A428 Black Cat to Caxton Gibbet improvements

9.103 Applicant's comments on the submissions made at
Deadline 6 Camcycle [REP6-077]

**9.103 Applicant's comments on the submissions made at Deadline 6
by Camcycle [REP6-077]**

TOSELAND ROAD - SUBMITTED SCHEME PROPOSALS

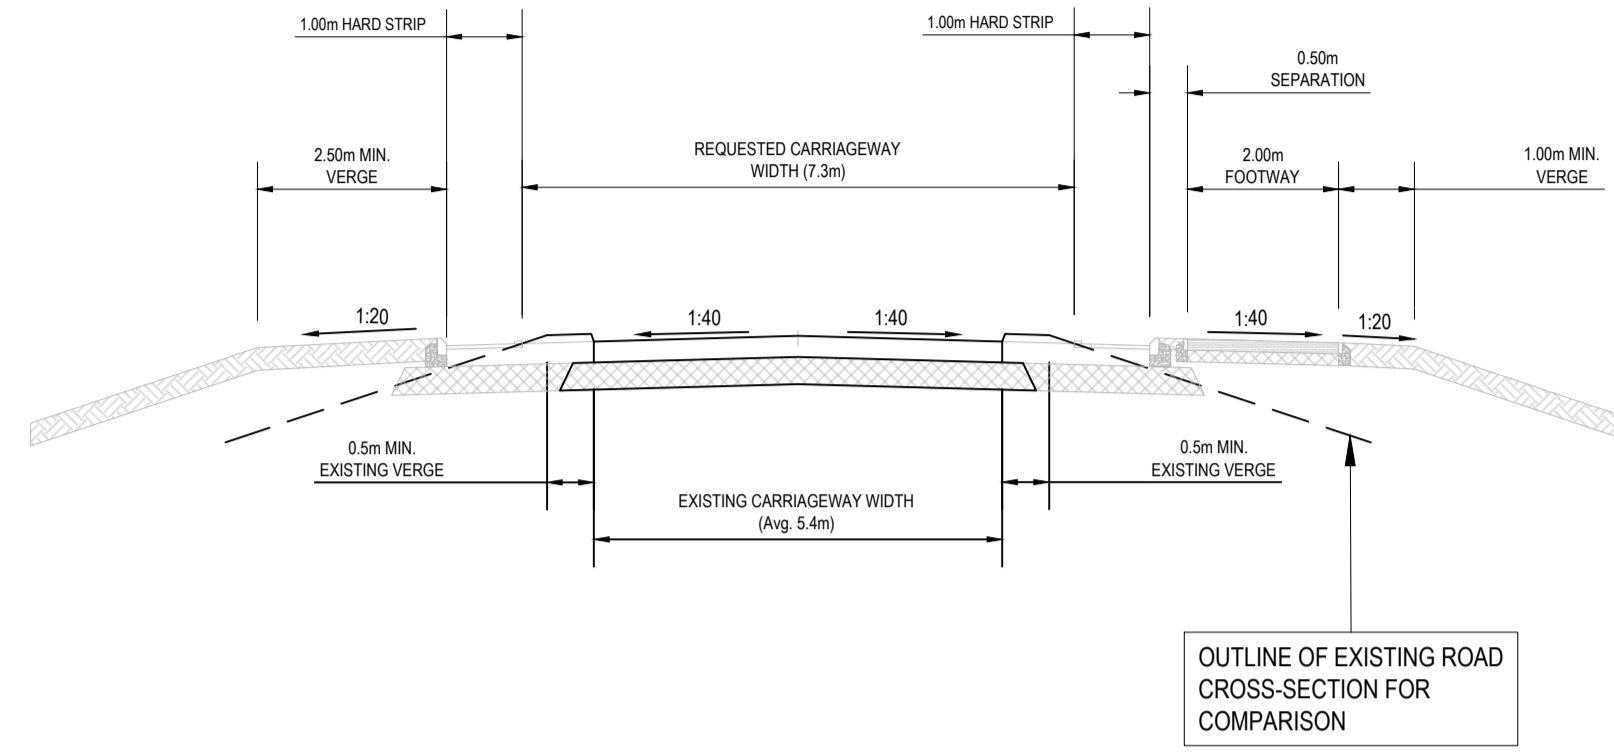
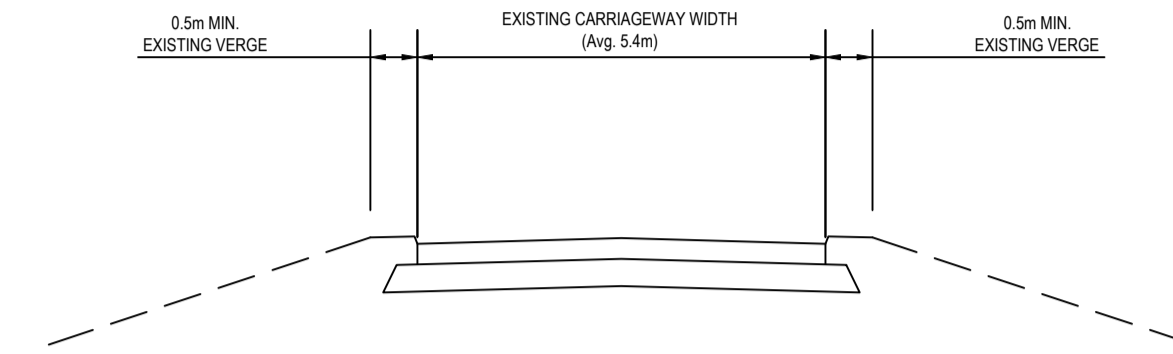
REP6-077v	<p>S31 Toseland Road Bridge: the structure provides a 4.0m wide space between parapet and kerb for an active travel route. According to Table 5-3 of LTN 1/20, there must be at least 0.5m of buffer space between the cycle route and any vertical obstruction over 0.6m tall (such as a bridge parapet). According to Table 6-1 of LTN 1/20, there should be 2.5m of separation between 60mph motor traffic and a cycle route, or an absolute minimum of 2.0m separation. This means that the effective width of the active travel route is only 1.0m (or 1.5m if following absolute minimum standards for protection). This effective width falls below the minimum standard of 3.0m for a lightly-used shared-use pathway as specified in Table 6-3 of LTN 1/20. To bring the Toseland Road Bridge into compliance with LTN 1/20 there should be: (a) a 0.5m horizontal separation between the parapet and the active travel route, (b) a 3.0m or wider active travel route, and (c) a 2.5m protective buffer between the 60mph motor traffic and the active travel</p>

Reference Number	Interested Parties Submission/Applicant's Comments
	<p>route (or 2.0m at an absolute minimum). The protective buffer should be designed to prevent motor vehicles from mounting it and parking on it. In addition, at either end of the bridge there is a very wide junction. Although these junctions are only intended to be used for emergency purposes, they interrupt the active travel route and leave people adrift in the middle of a wide and dangerous carriageway where motor vehicles may be travelling at 60mph. This issue can be resolved by gently bending the active travel route away from the carriageway such that it crosses the emergency access roads at places where they are much narrower. See figure 10.18 of LTN 1/20 for more details about designing such crossings of priority junctions.</p>
Applicant's comments	<p>The Applicant does not accept that LTN1/20 applies to this Scheme. Please see the response to REP6-077a.</p> <p>The route over the new bridge is a footway only. This is provided as part of the diversion of Footpath 278/7. There is no existing off road cycling route along Toseland Road and there is no justification for providing such facilities over the length of the new bridge.</p>
